David Way  
Department of Planning, Industry and  
Environment  
Locked Bag 5022  
PARRAMATTA NSW 2124

**Subject:** Exhibition – Environmental Impact Statement for the New Liverpool Primary School (SSD-10391)

PROJECT NUMBER 20099	DRAWING NUMBER NLPS-LA-SSD-0202-DRG(01)
PHASE SCHEMATIC DESIGN

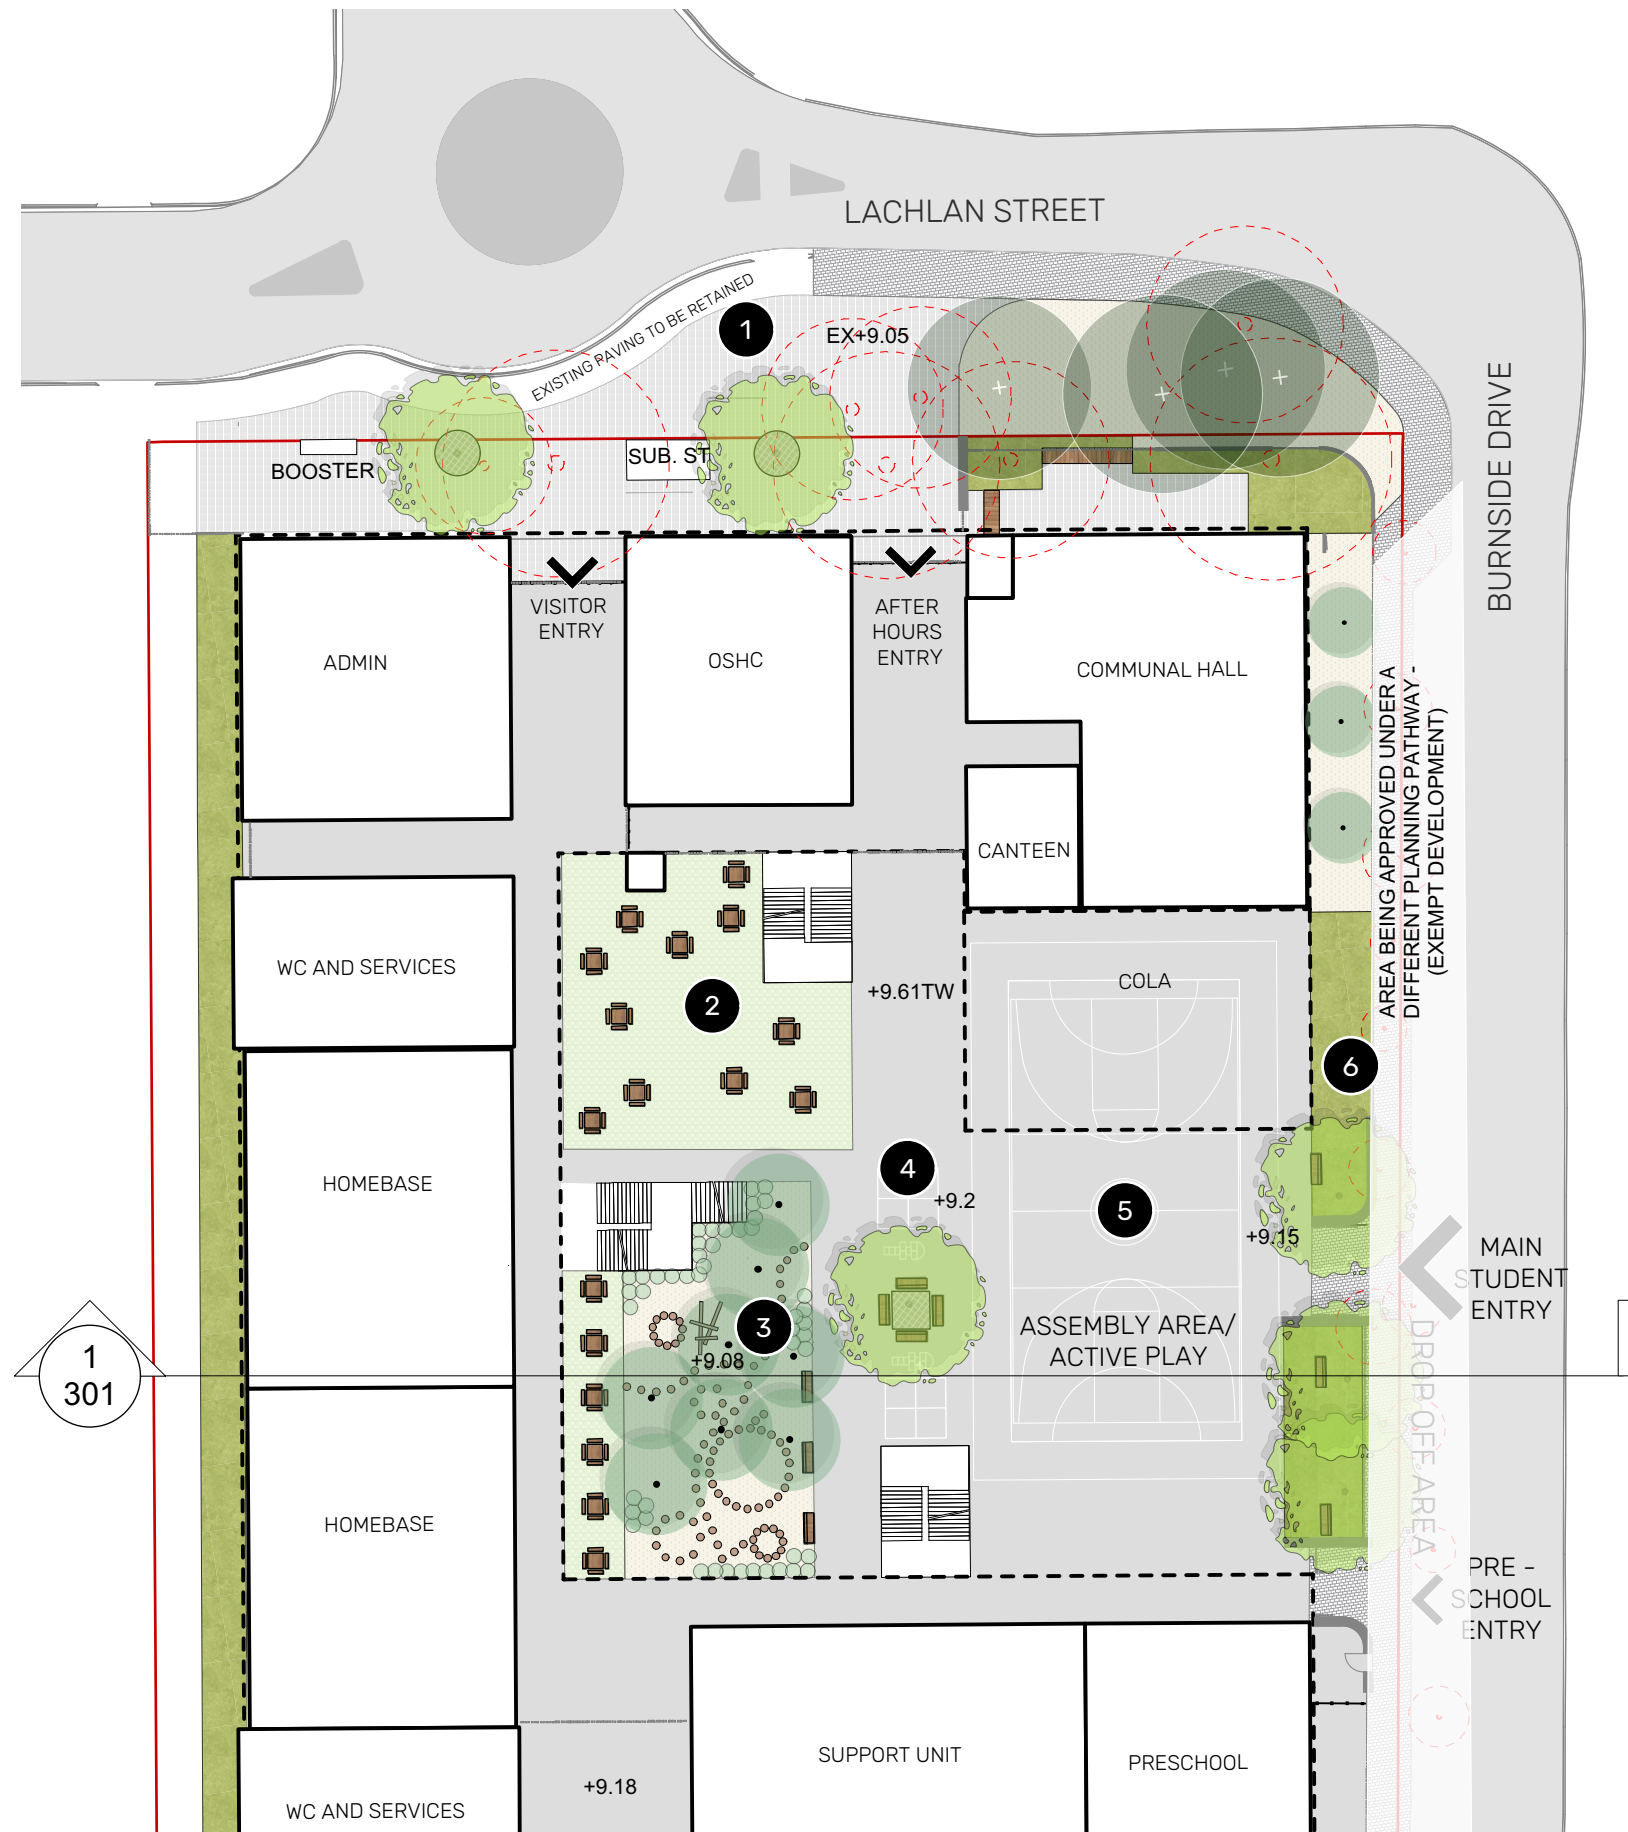
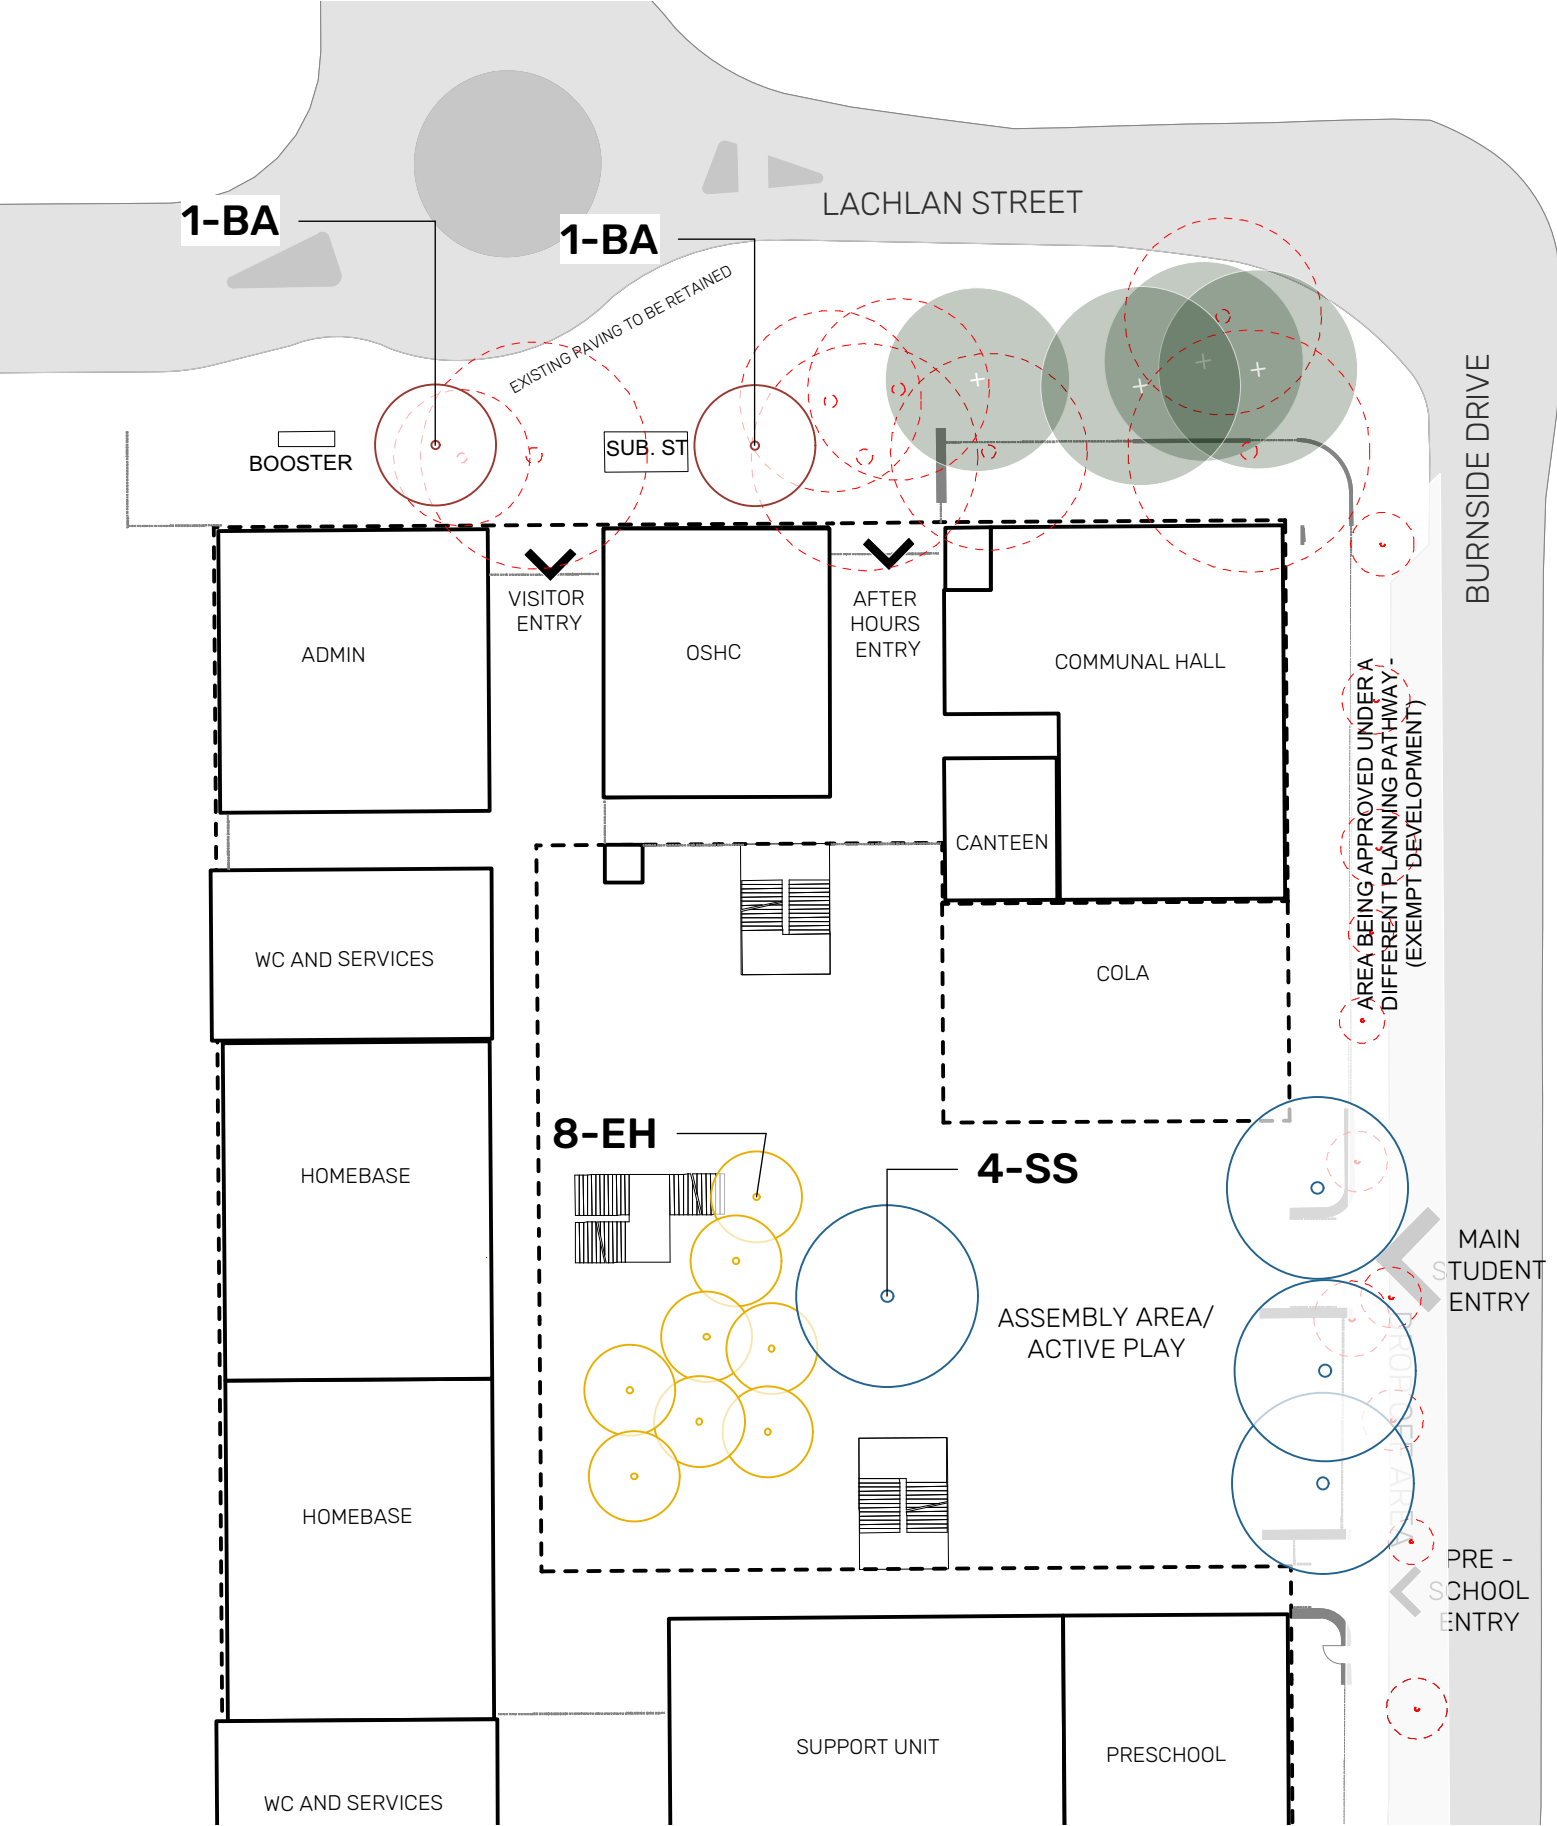
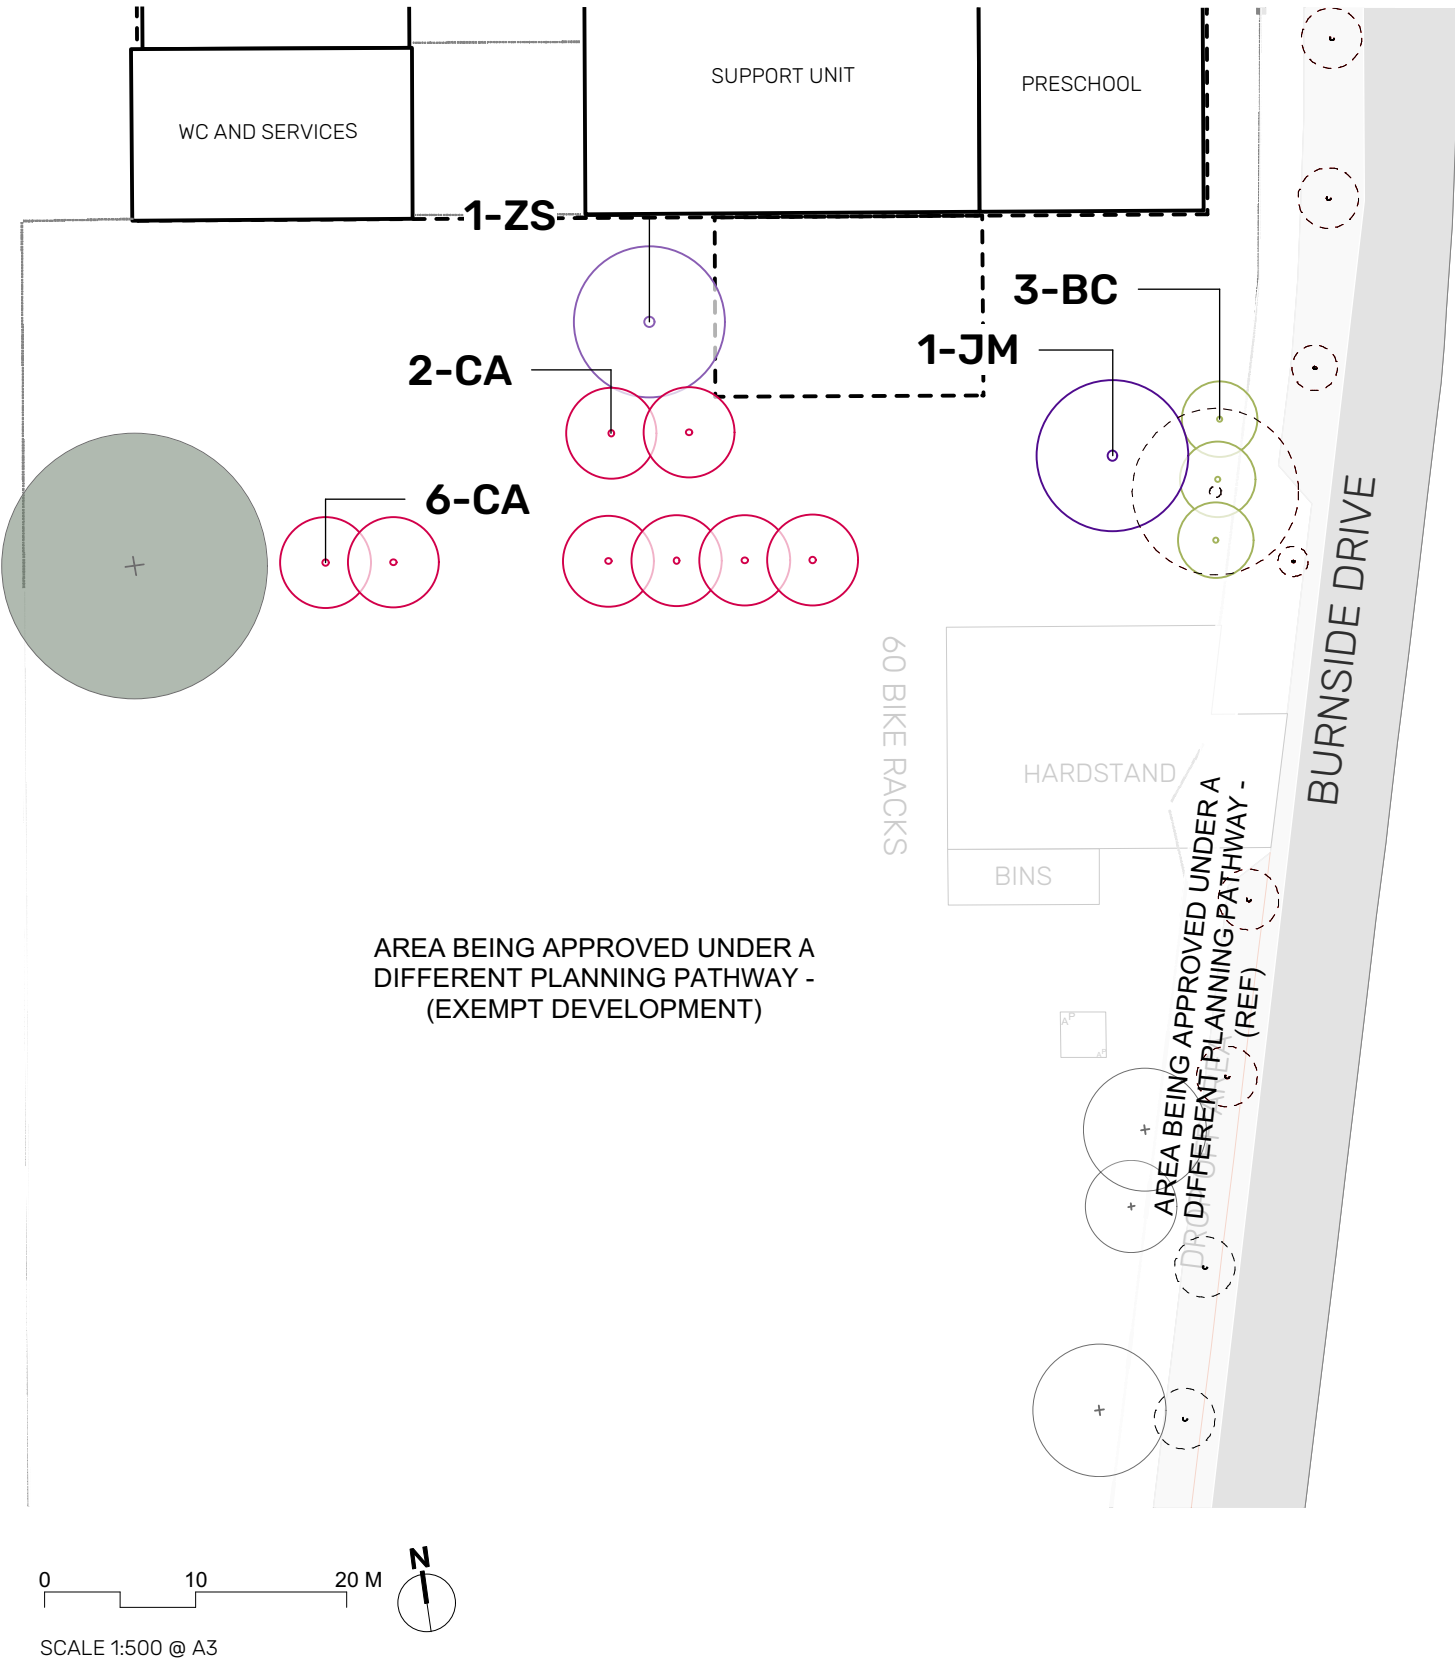
EES does not support the planting of Chinese Tallow Tree on the site as they are classified as weeds: <https://weeds.dpi.nsw.gov.au/Weeds/Details/38>. EES recommends the *New Liverpool Primary School Landscape Concept Design report* (spackman mossop michael, May 2021) be amended to substitute Chinese Tallow Tree for a native species.
